From: paul.marshall@hertfordshire.gov.uk
To: [Planning](#)
Subject: Planning application 6/2019/2714/OUTLINE - YMCA, 90 Peartree Lane
Date: 20 January 2020 15:29:13

Response to Planning application from Hertfordshire County Council (T and CP GDP Order 2015)

District ref: 6/2019/2714/OUTLINE

YMCA, 90 Peartree Lane
Welwyn Garden City
AL7 3UL

Drawing file: 1903-19 SP06 - 12m refuse vehicle.pdf

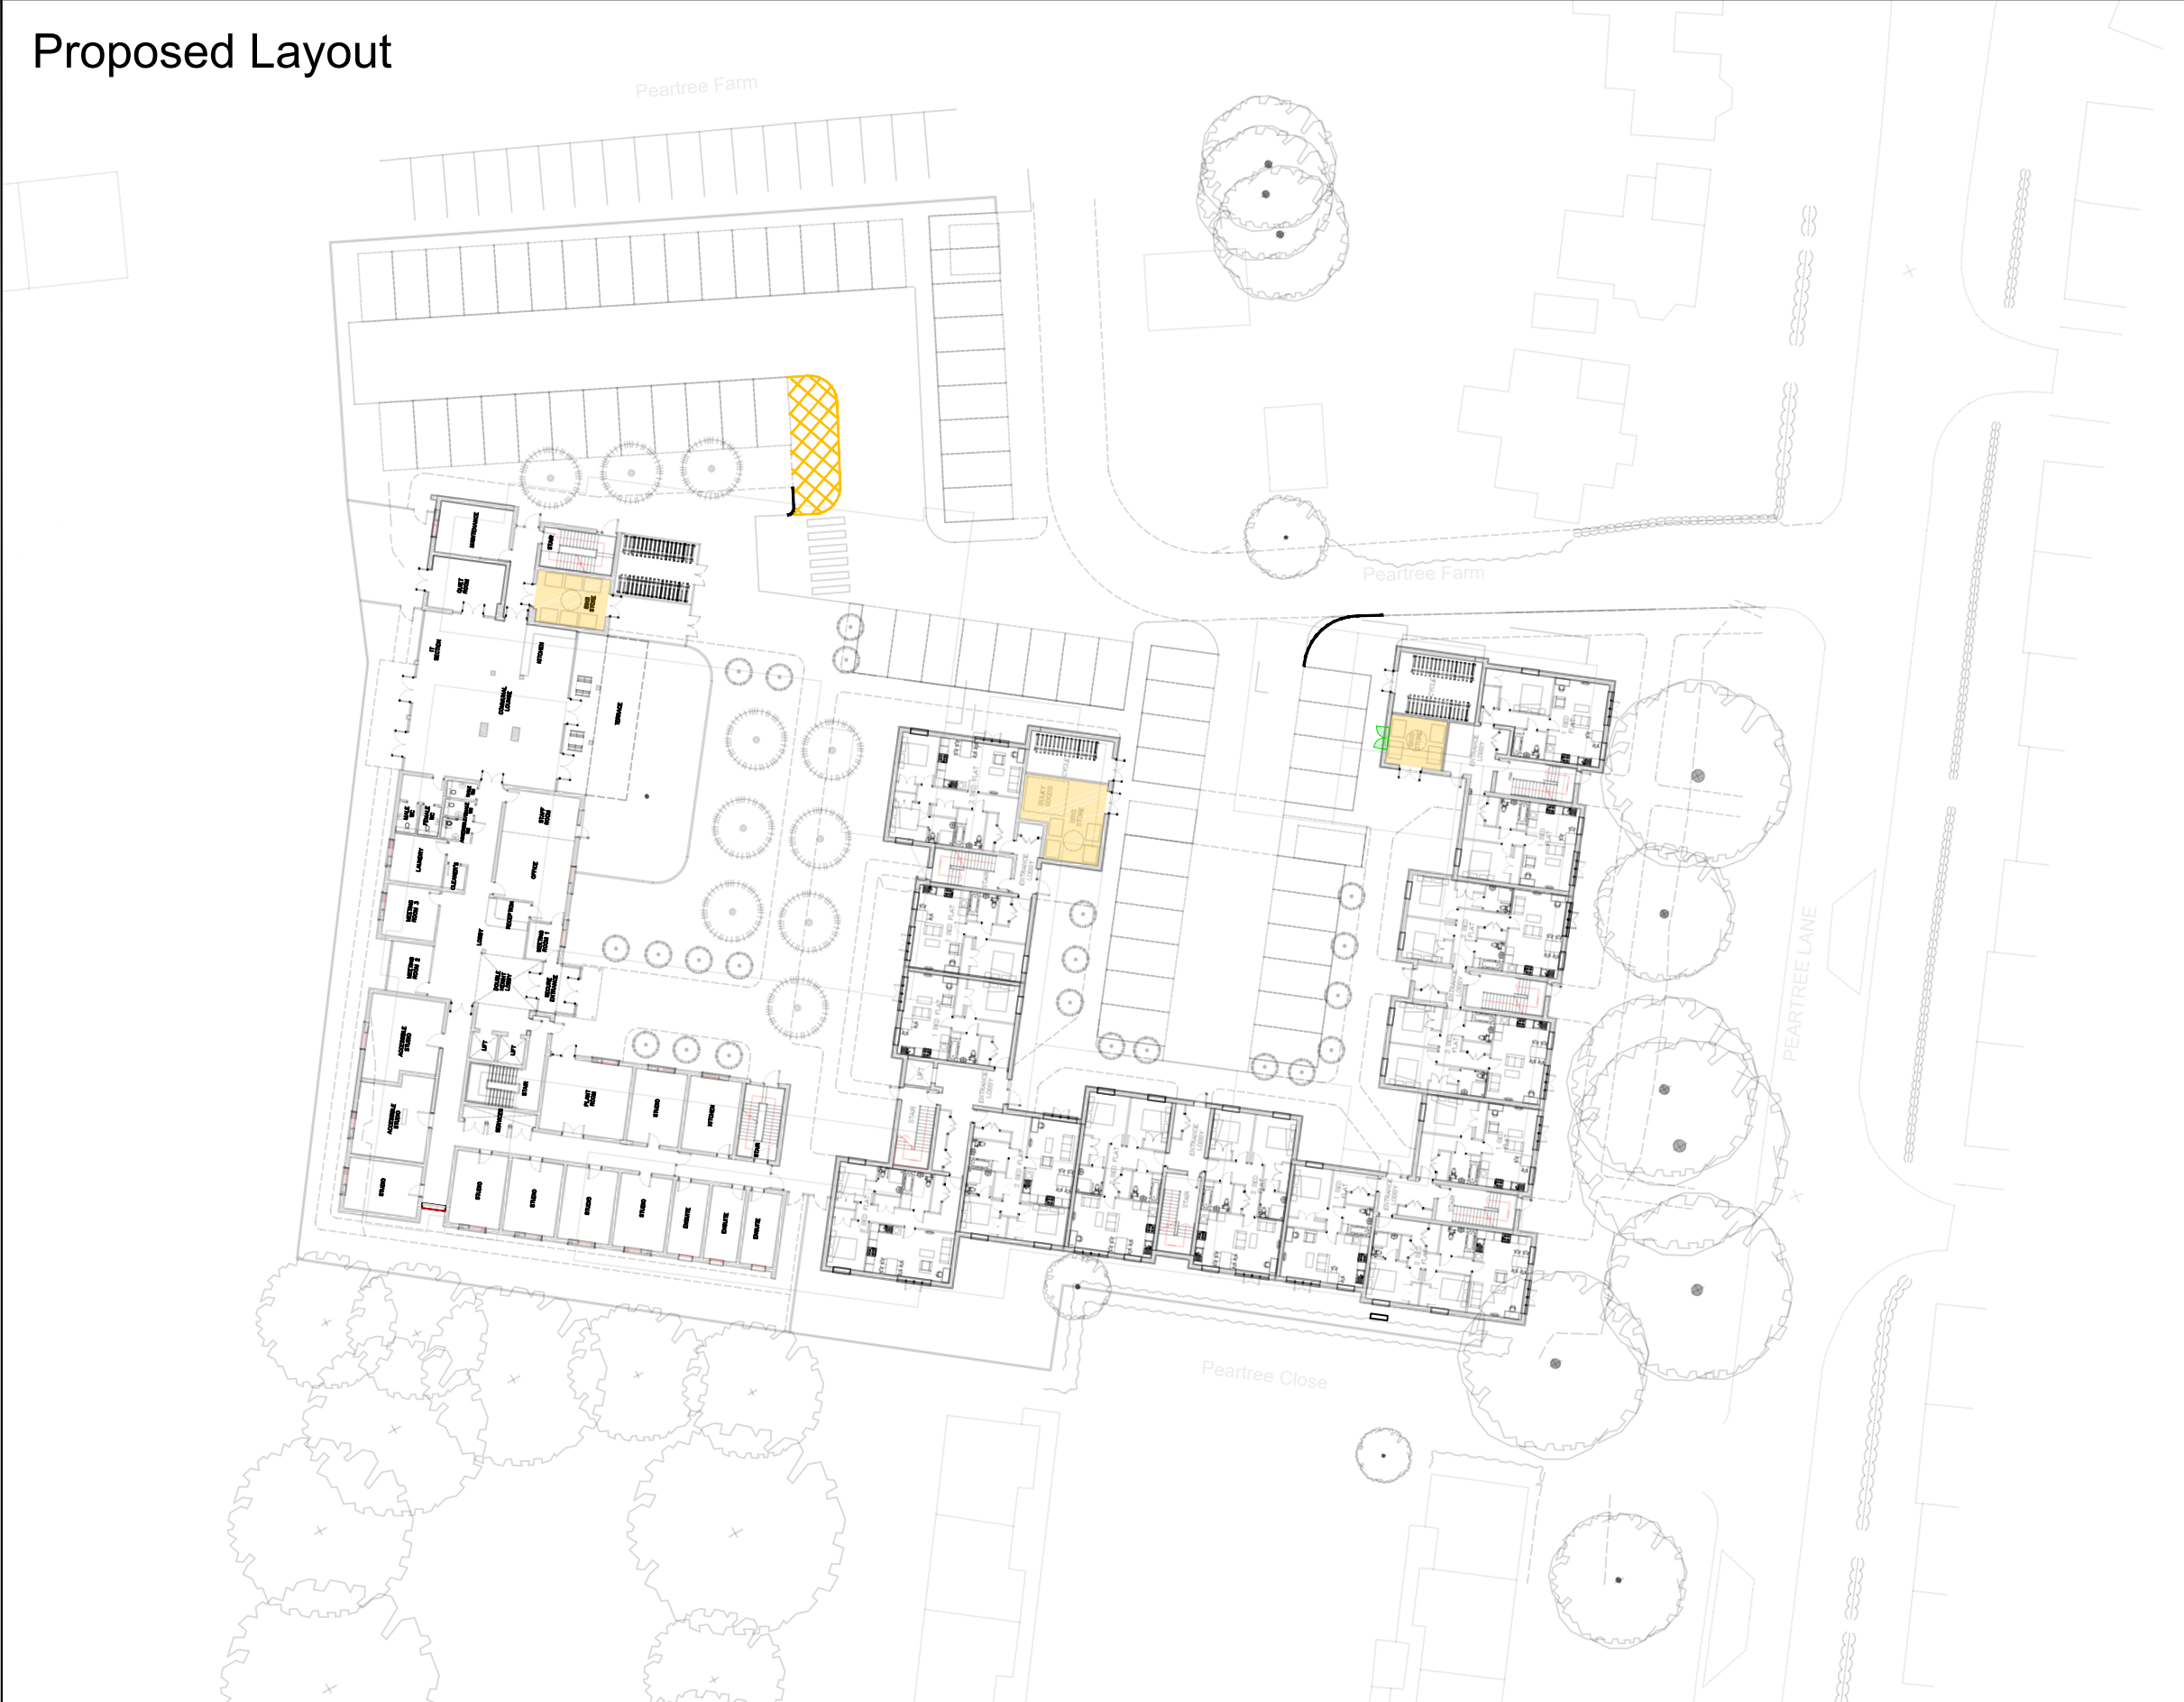
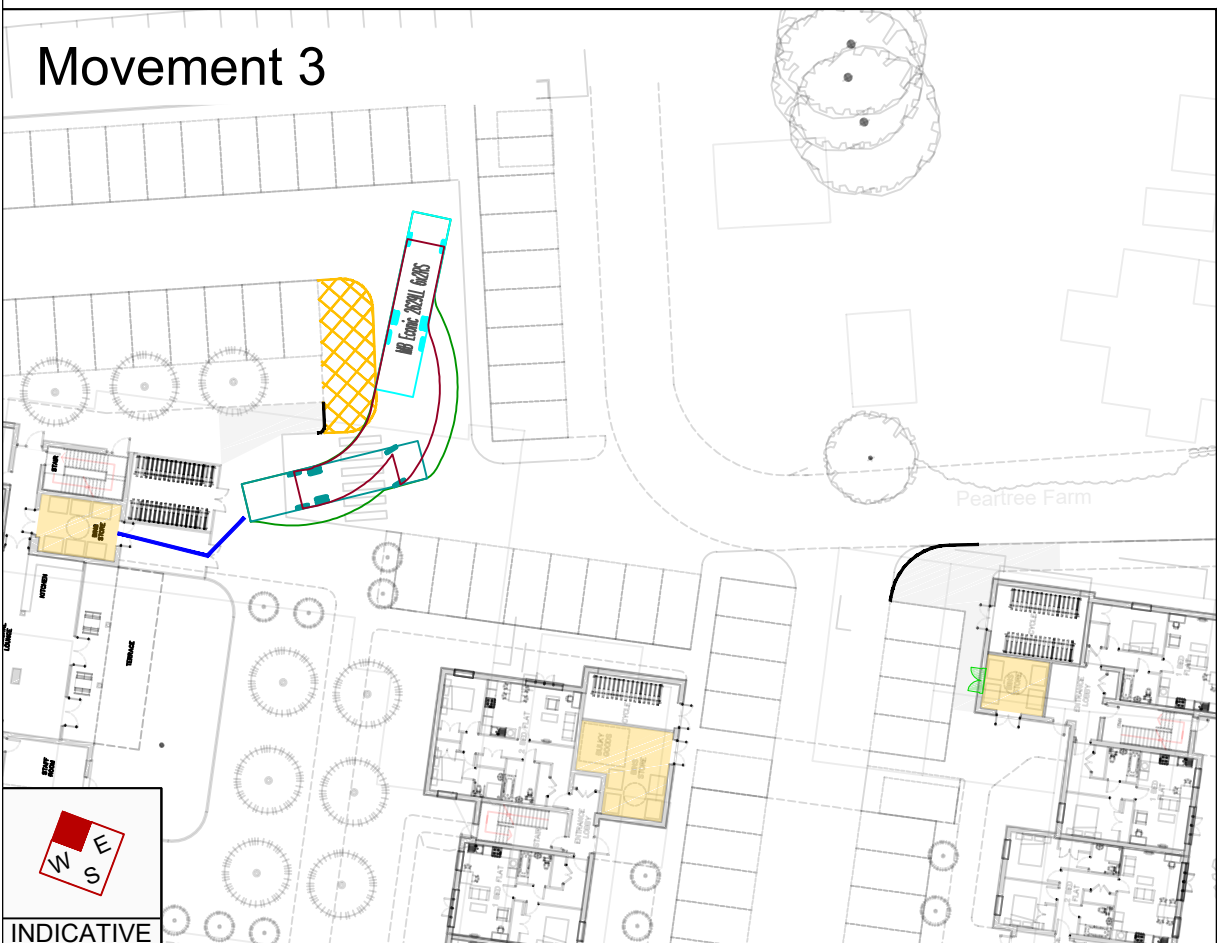
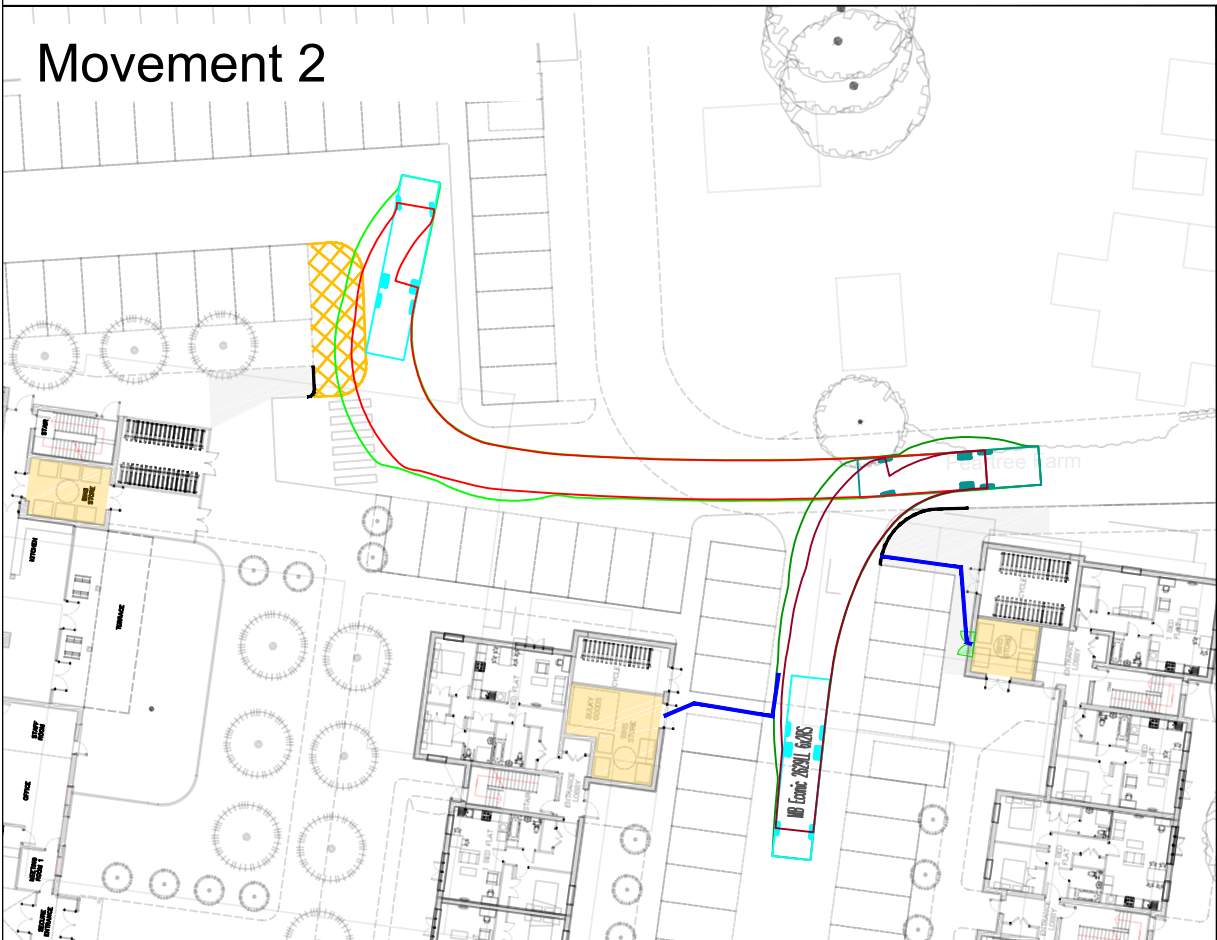
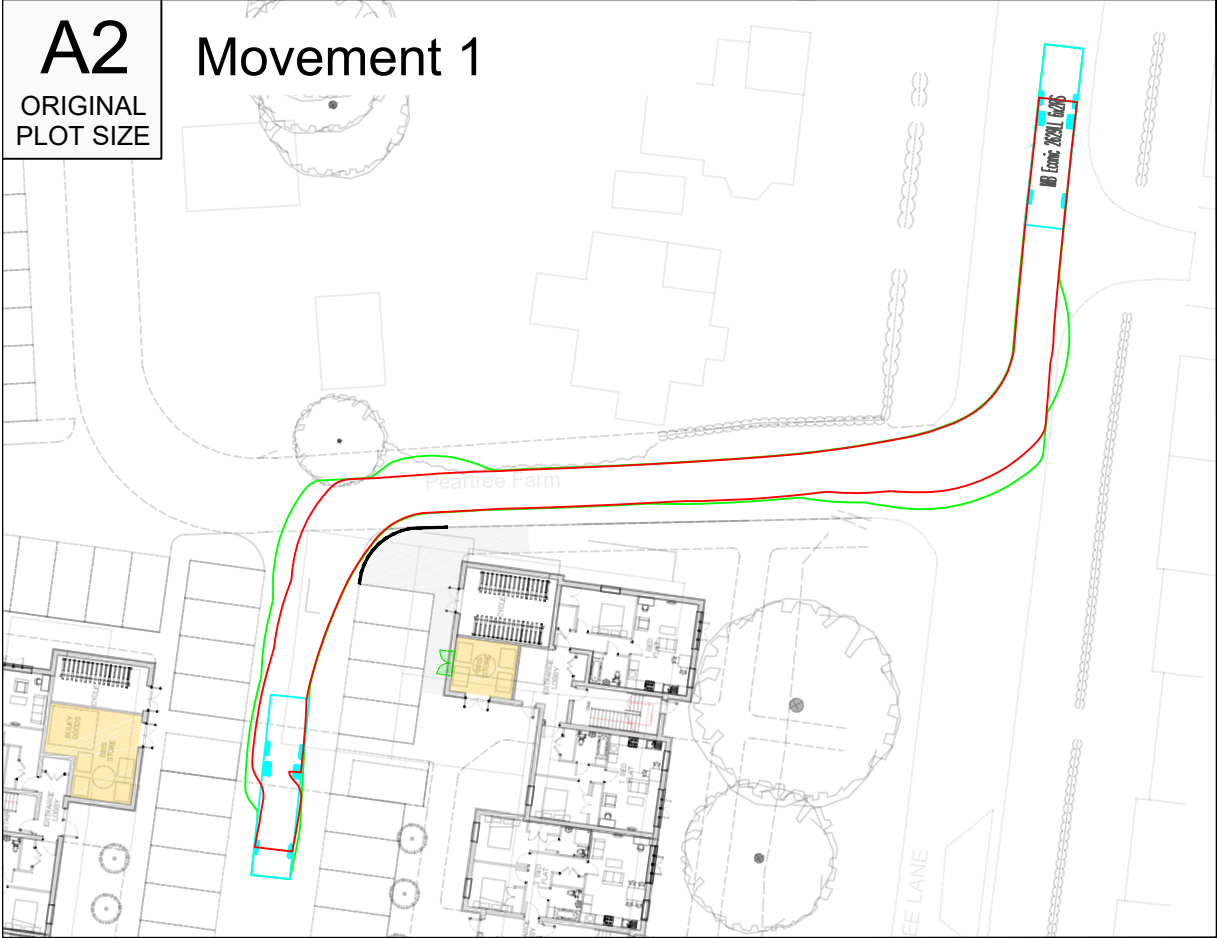
The Highway Authority are unable to recommend the grant of planning permission at this time. The applicant has not demonstrated a swept path analysis for vehicles of 12.1m in length. The swept path analysis provided is for vehicle lengths of 11.1m which of itself has not successfully demonstrated unimpeded access.

The proposed site layout has not been successfully tested with a swept path analysis on (drawings SP01,02, and 03 A) with a waste collection vehicle (11.2m long). Vehicles should be a minimum of 12.1m.
